Post Approval – Consultation

Post Approval Consultation Record

From: [Jake Hausfeld](#)
To: [Tom Hemmett](#)
Cc: [Isaac Pinkerton](#)
Subject: RE: Road Safety Audit - Jordan Springs Public School
Date: Tuesday, 24 March 2020 3:20:15 PM
Attachments: [image001.png](#)
[image002.png](#)
[image003.jpg](#)
[image004.jpg](#)

Detailed design road safety audit

FOR S138 APPROVAL

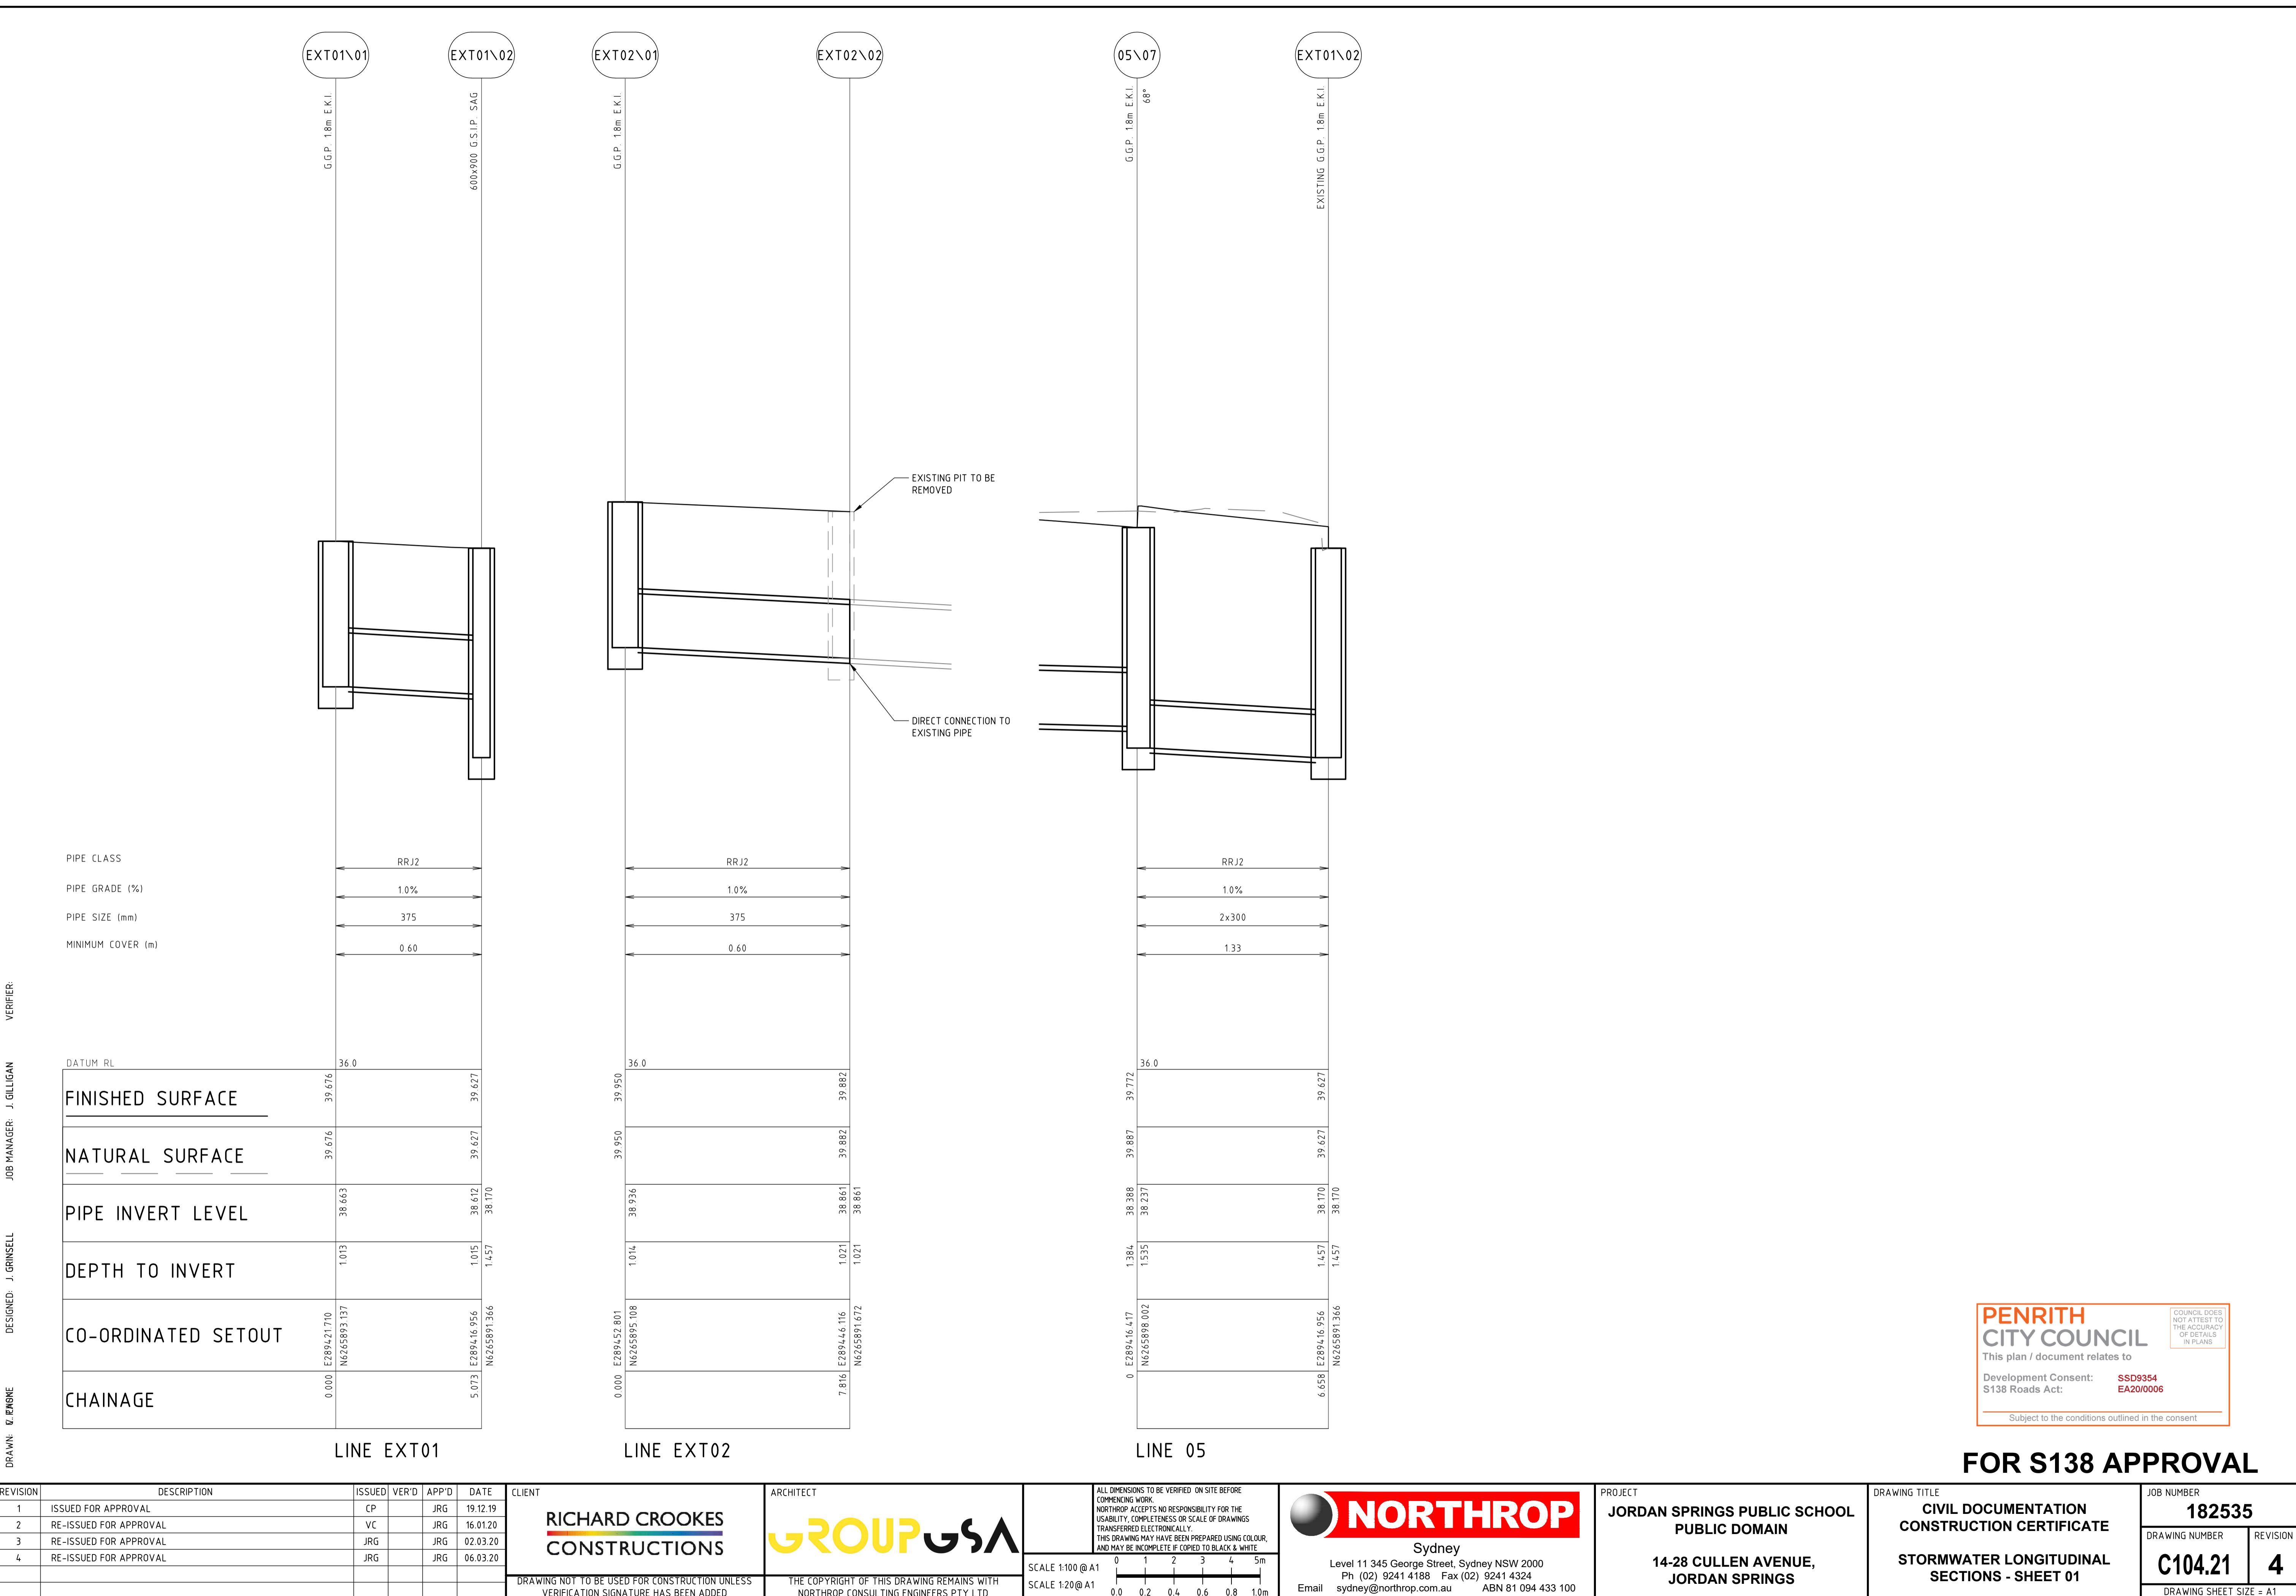
- The substation and associated easement adjoining the proposed staff parking from Lakeside Parade will not allow for the implementation of an egress path enabling students to avoid crossing the driveway fronting Lakeside Parade.
- The additional signage and line marking referenced in your response comment to item 4b is assumed to be that which has been shown on the approved signage and line marking plans. Any additional signage and line marking to this is subject to further review by Council.
- I agree with the recommendation in the report that a pick-up management strategy for the indented bay is developed. However I note that this is an operational requirement and outside the scope of the construction works.
